CROSSROADS MIXED USE FILING NO. 2

CONSTRUCTION PLANS

JULY 2023

EL PASO COUNTY FILE NO. SF2238

CONTRACTOR SHALL ADJUST ALL EXISTING VALVE COVERS, SANITARY AND STORM SEWER MANHOLE RIMS, ELECTRIC VAULTS THAT LAY WITHIN THE PROPOSED PAVEMENT, CONCRETE CURB AND SIDEWALKS. ANY CONFLICTS SHALL BE COORDINATED WITH THE ENGINEER.

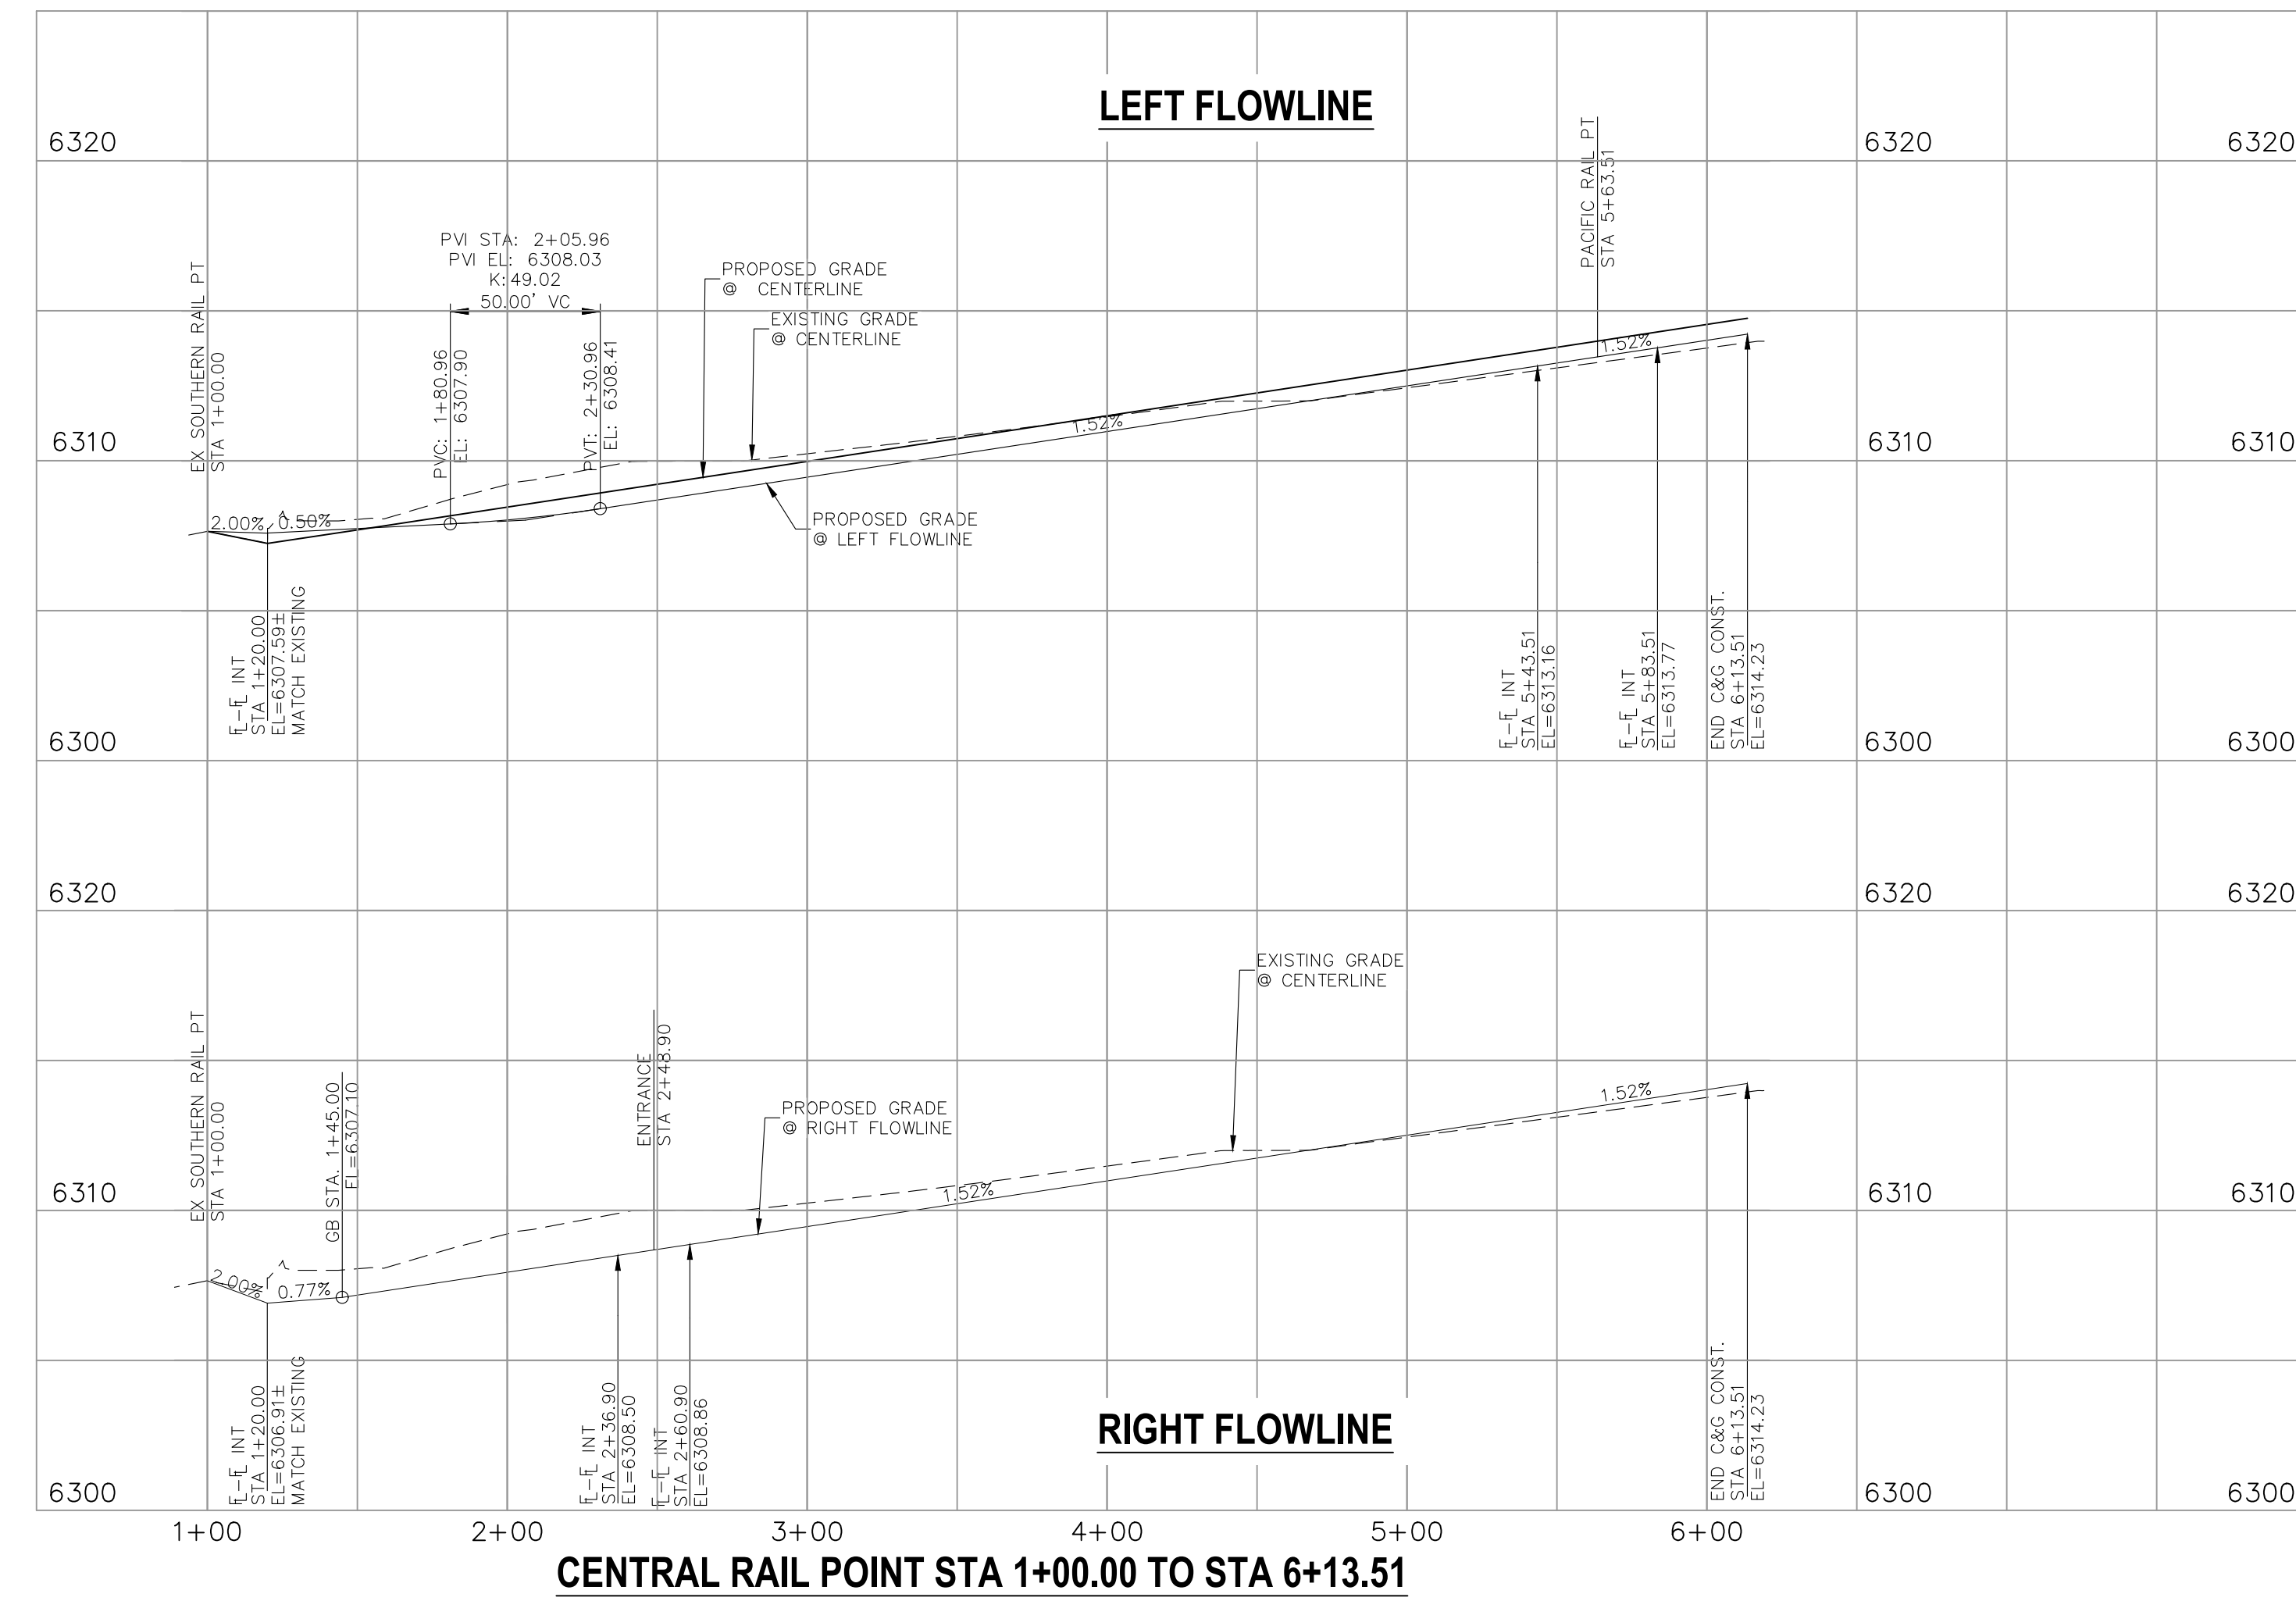
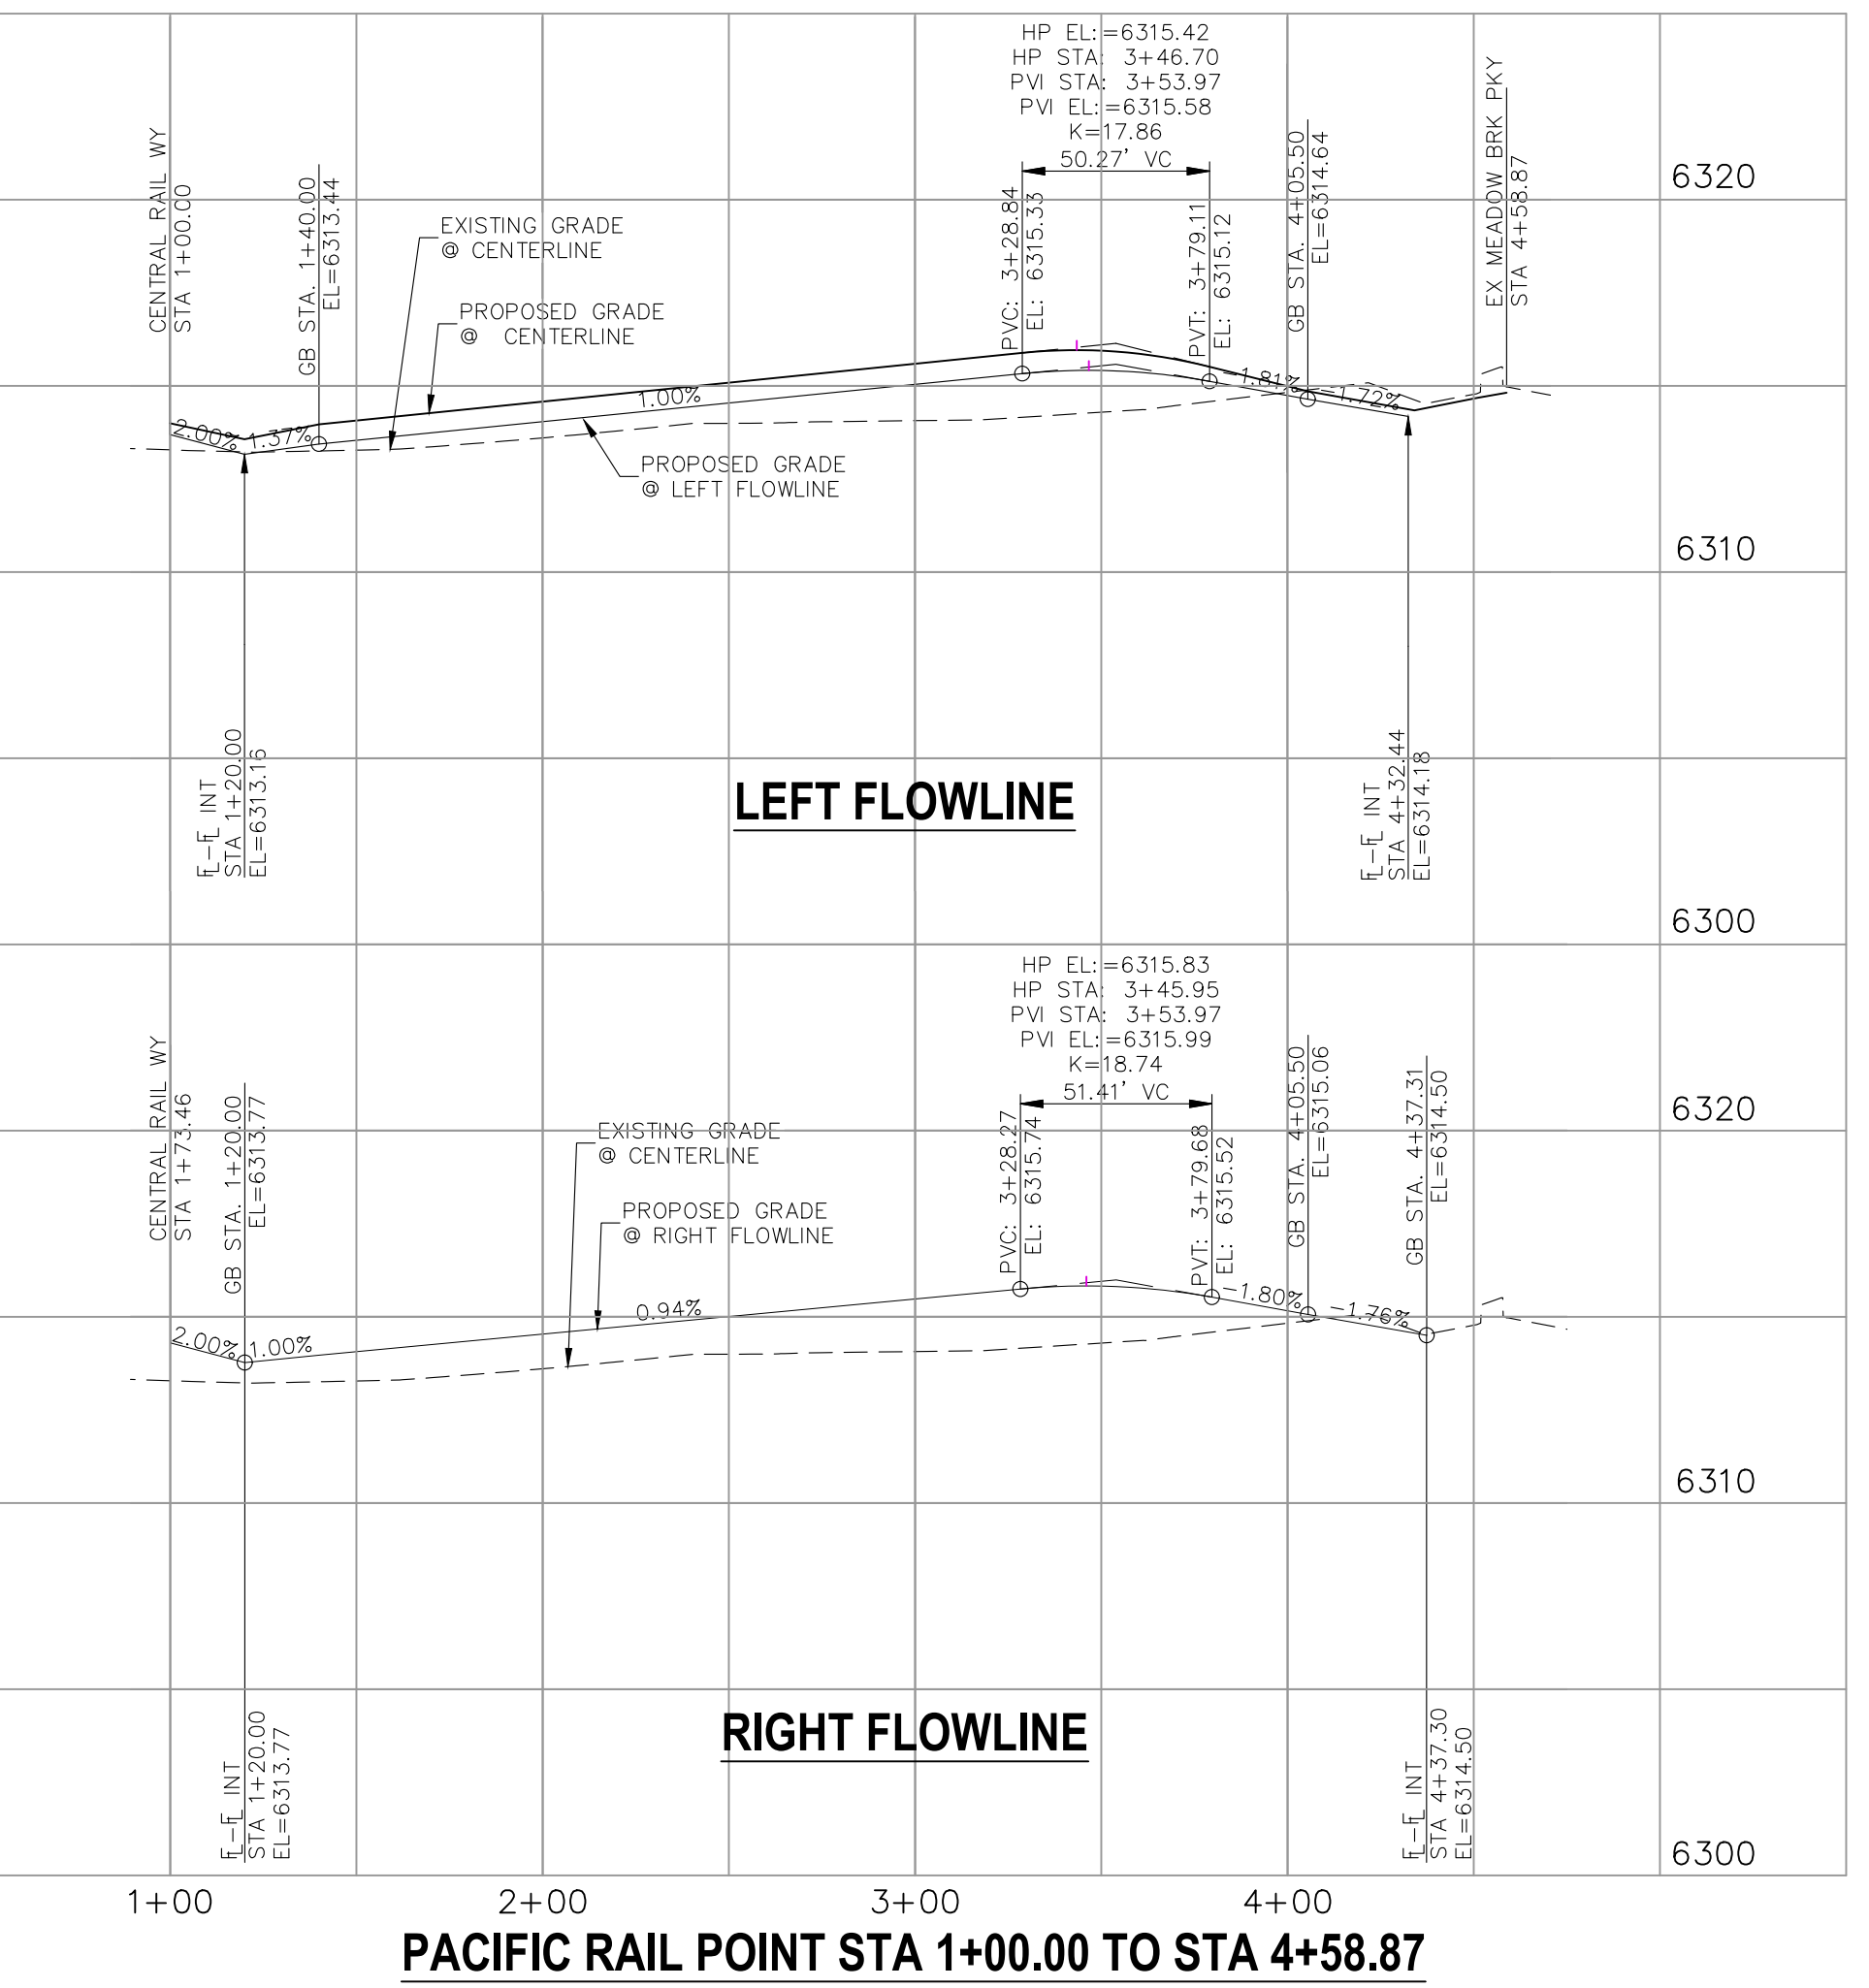
cross section shows detached. revise

It was indicated in the preliminary plan deviation and the submitted TIS that these would have a design and posted speed of 25 mph similar to a urban local classification. Please revise. Also please add note on the cross sections: per deviation request from Preliminary Plan SP2011

revise to Tract D as there is no longer a lot 2

Please extend to show the entire sidewalk along Southern Rail Pt and how it ties to the sidewalk along Meadowbrook.

Add arrows to legend

Provide receiving pedestrian ramp across the street.

Refer to EDM 2.5.2.C.3

Label

cross section show a detached sidewalk, revise to match.

Label. Provide information.

Please revise the drawings and texts so that there is no conflict. Will there be curbs cuts and a driveway for or will the sidewalk continue through?

Provide matchlines on all drawings.

Show and label running slope and cross slope on sidewalks.

**CENTRAL RAIL POINT &
EX SOUTHERN RAIL POINT**

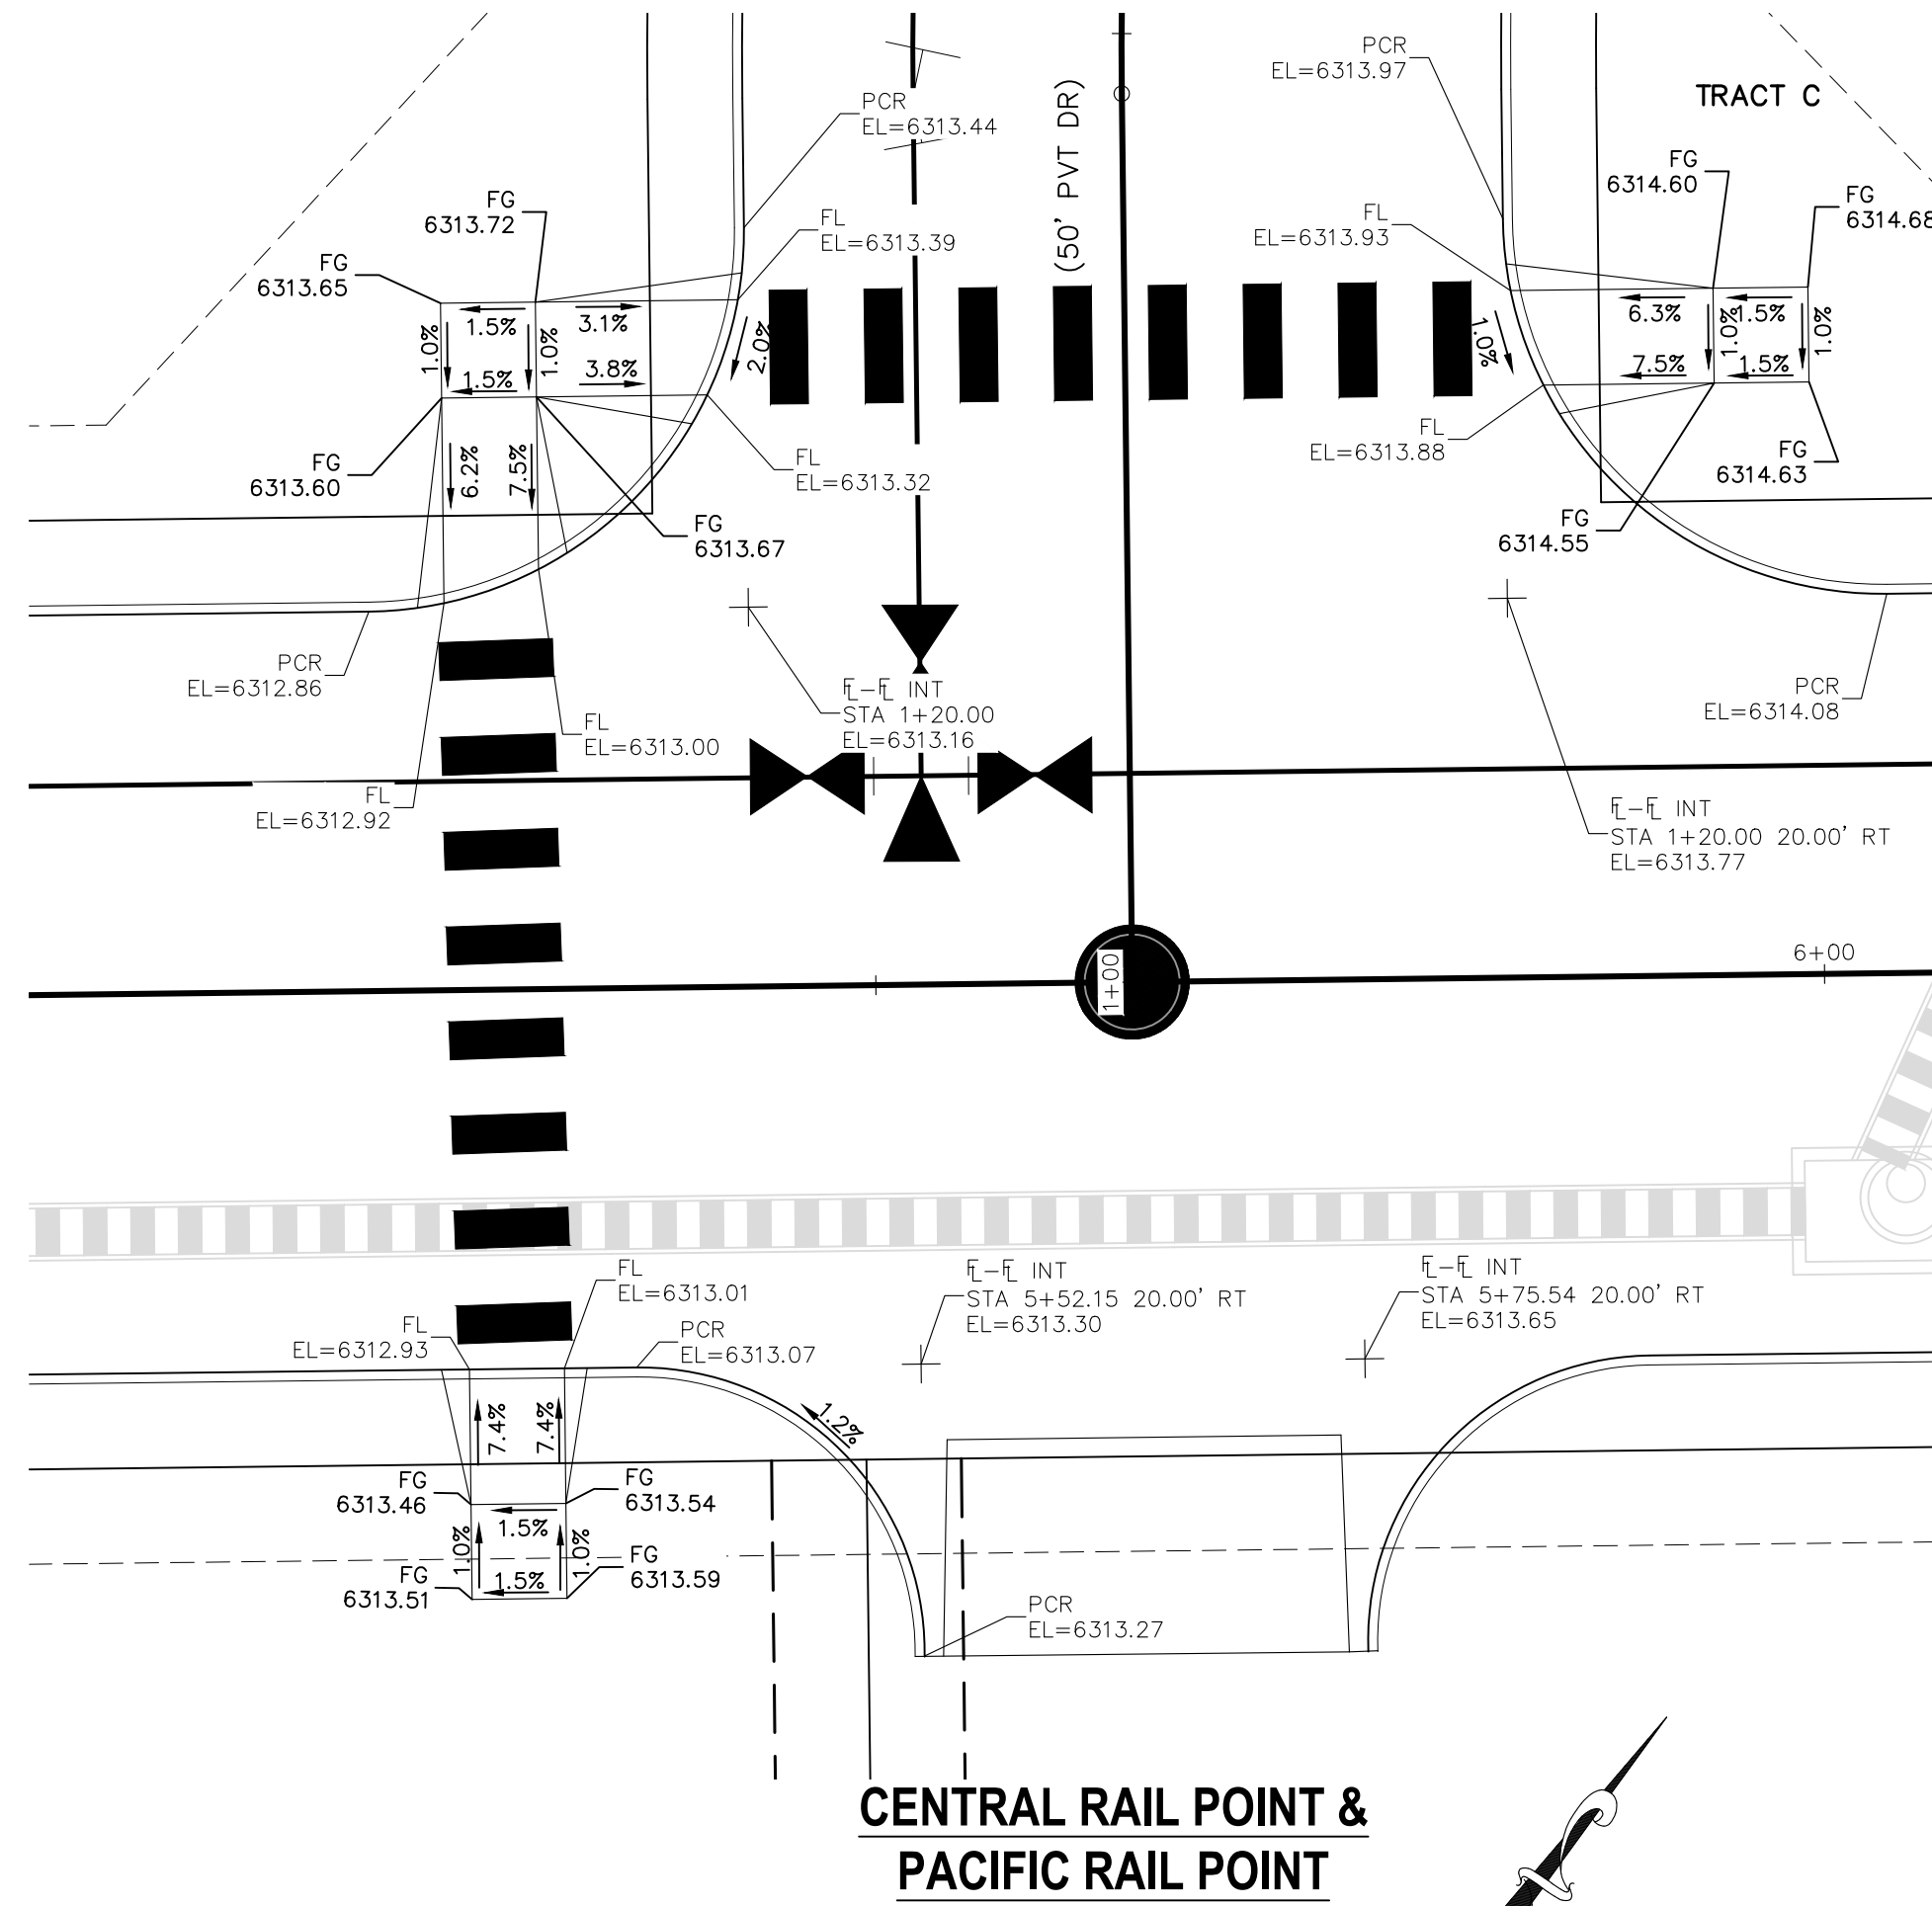
provide truncated dome
